PLANNING AMENDMENT

Application no: H22/0314/01

Description: Erect detached double garage

Amendment: Re-site garage.
Dwg.Nos.210/01/02B

AMENDED PLAN
Ref. A1

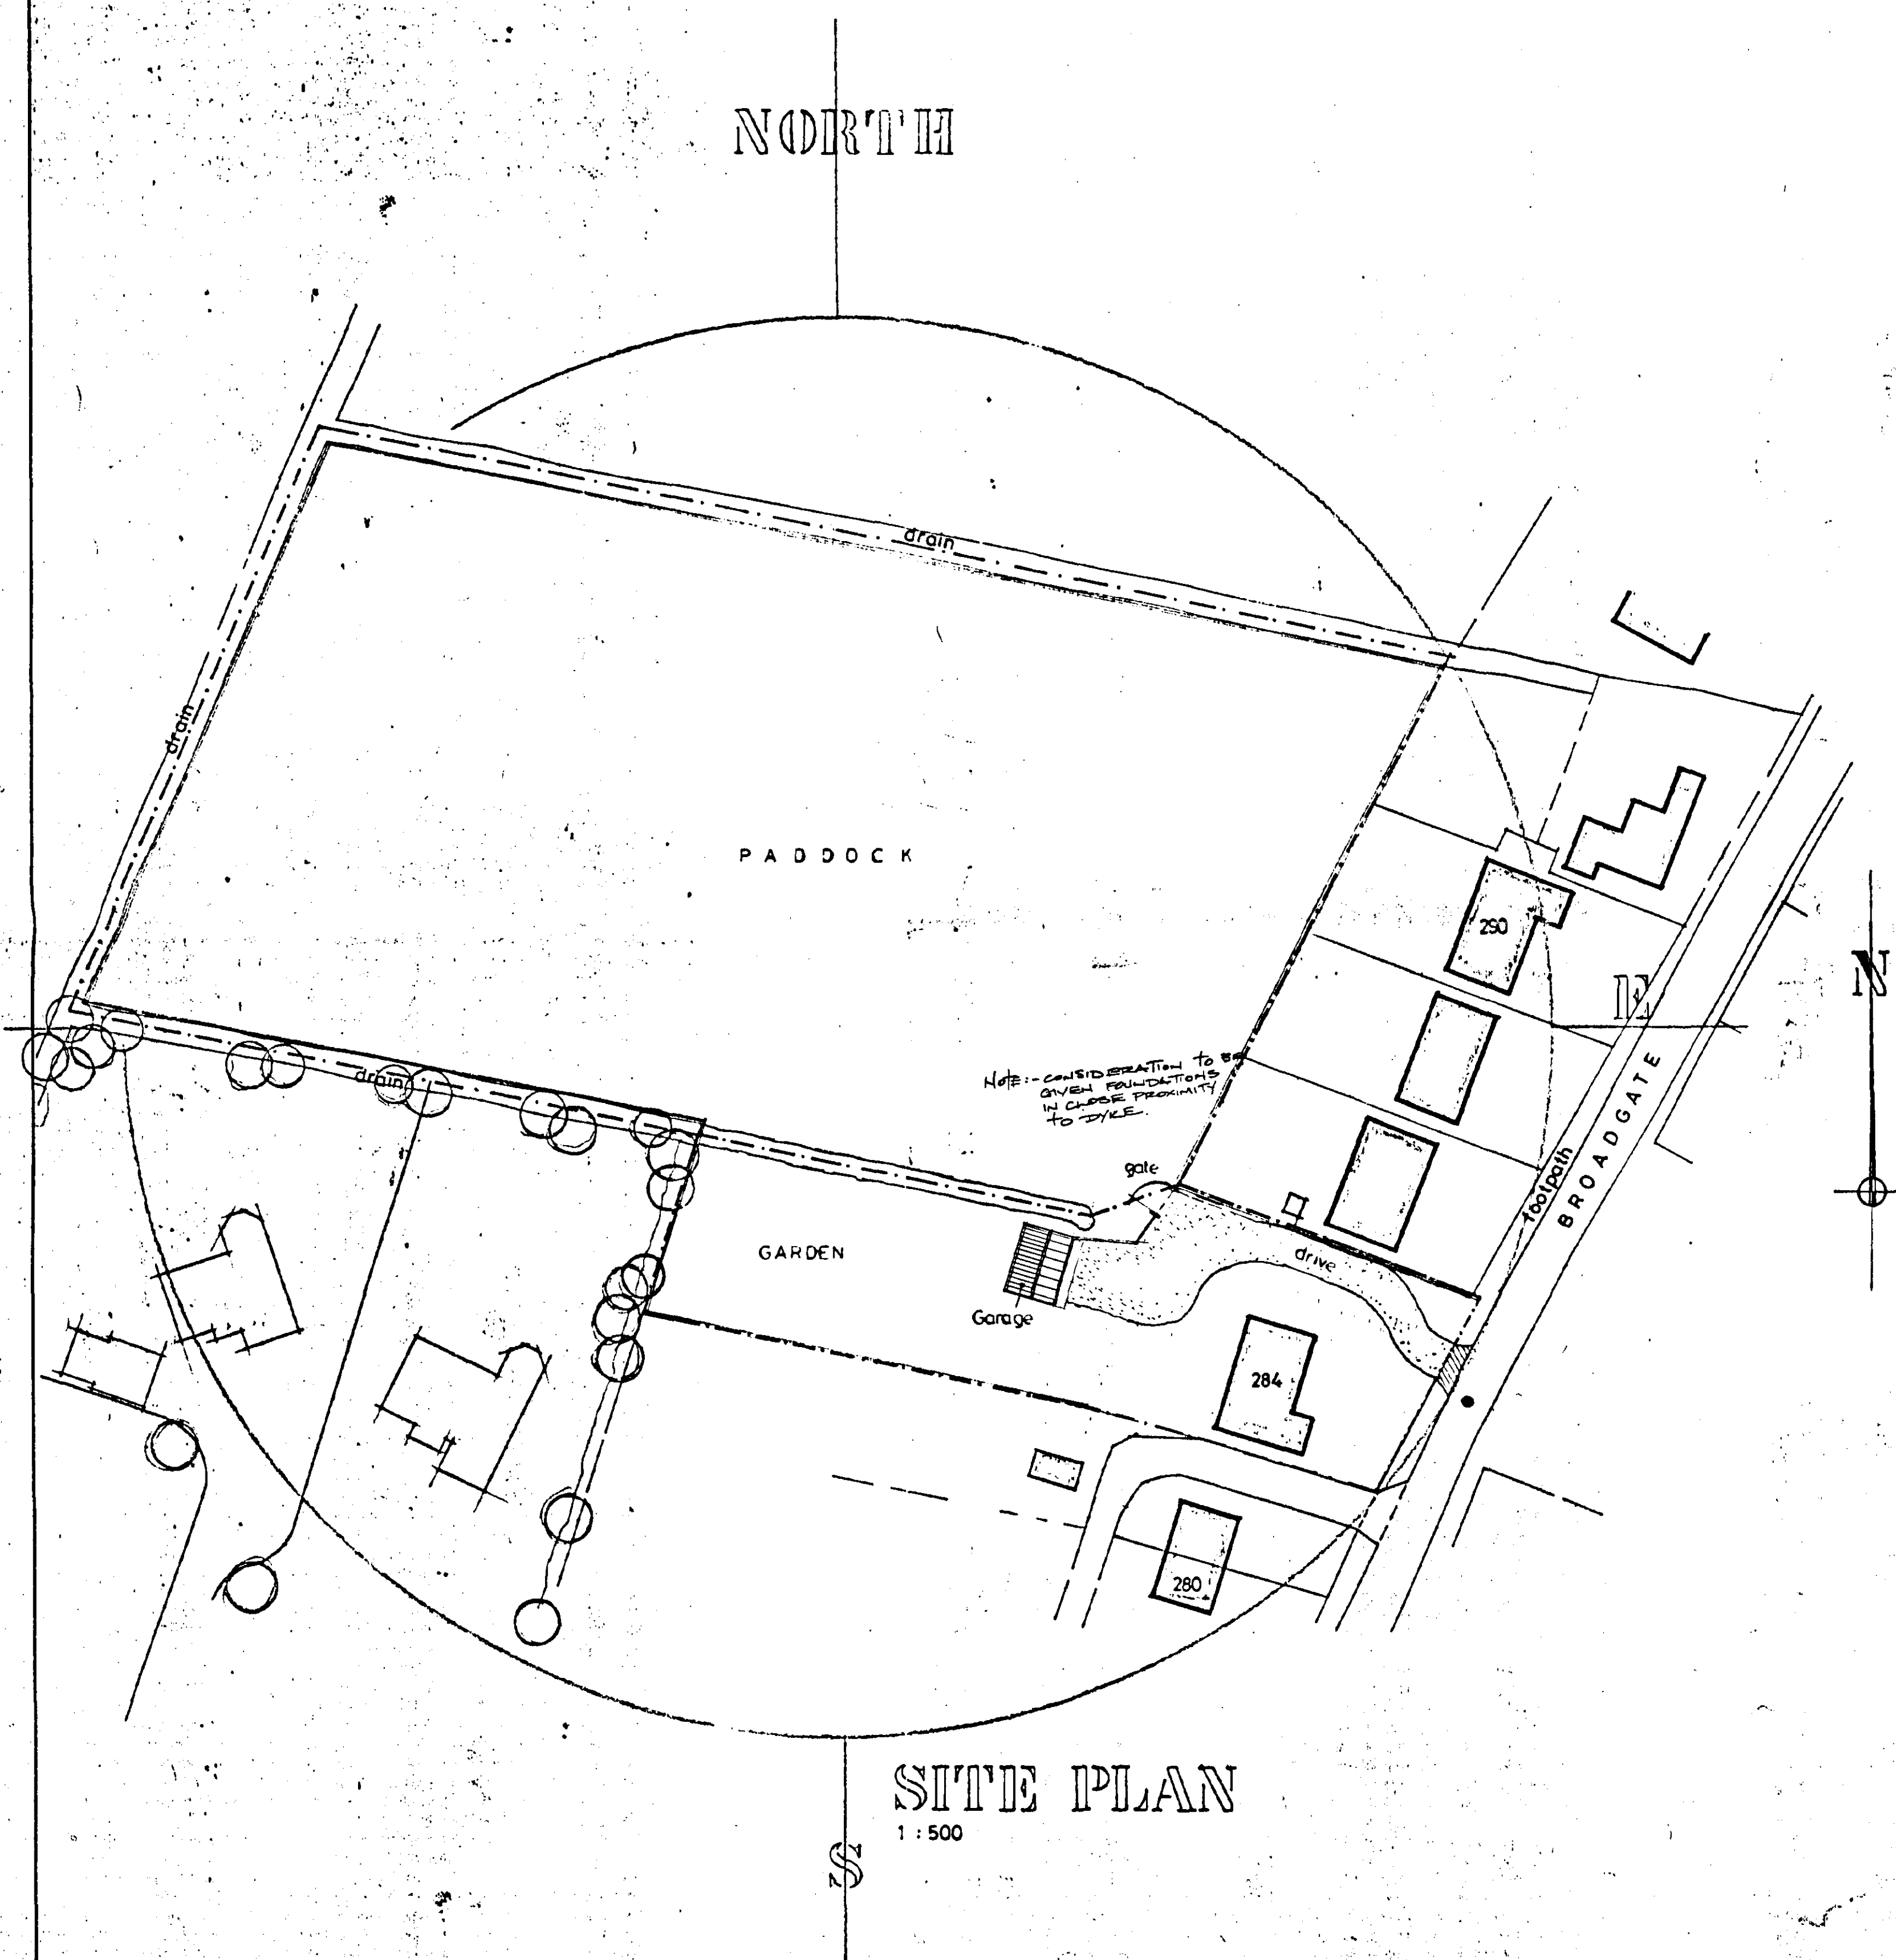
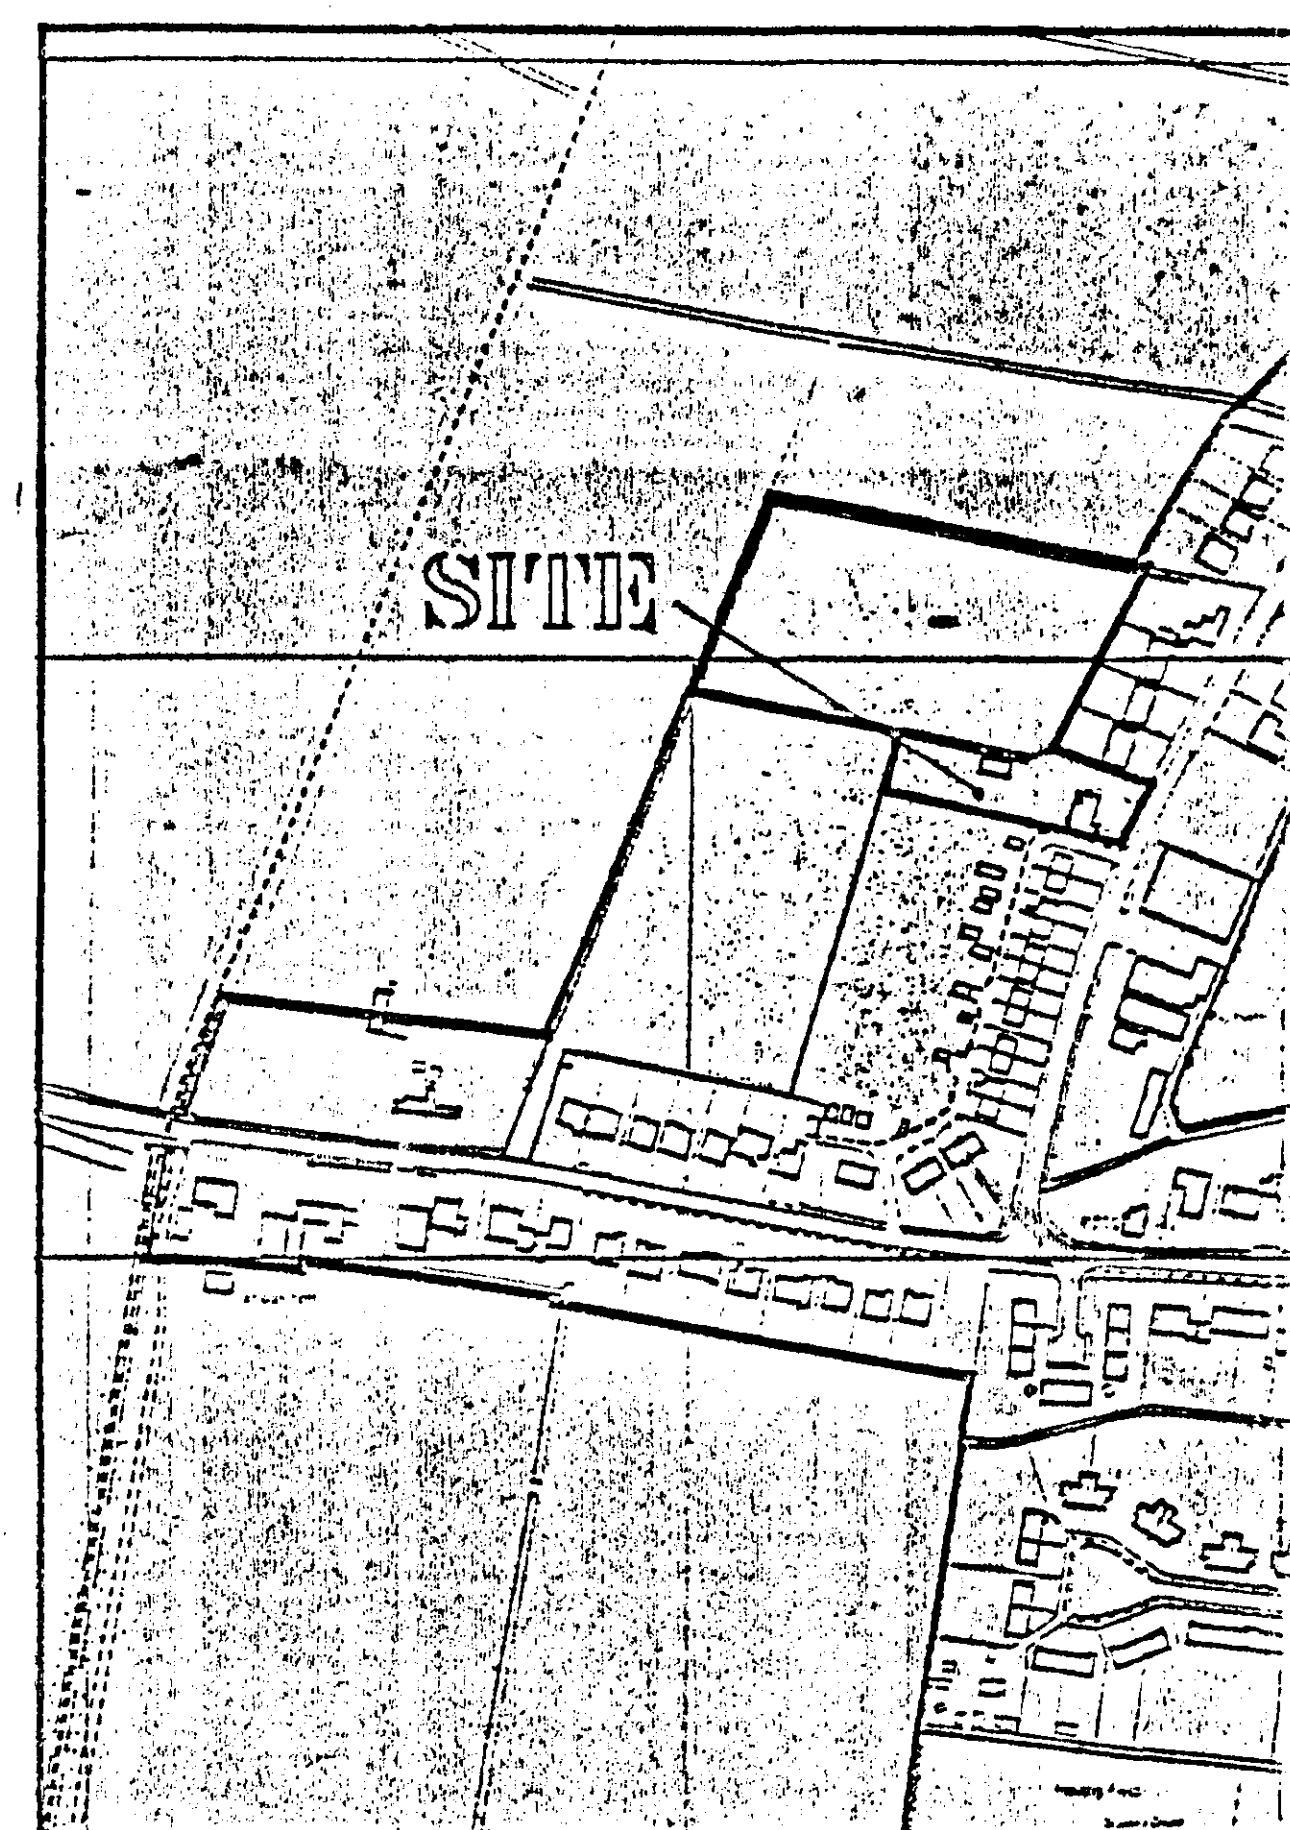
RE-SITE GARAGE
(AWAY FROM OLD
SEPTIC TANK)

The amended details submitted in respect of the above proposal have now been considered and there are no objections to the amendment being implemented to the extent described above.
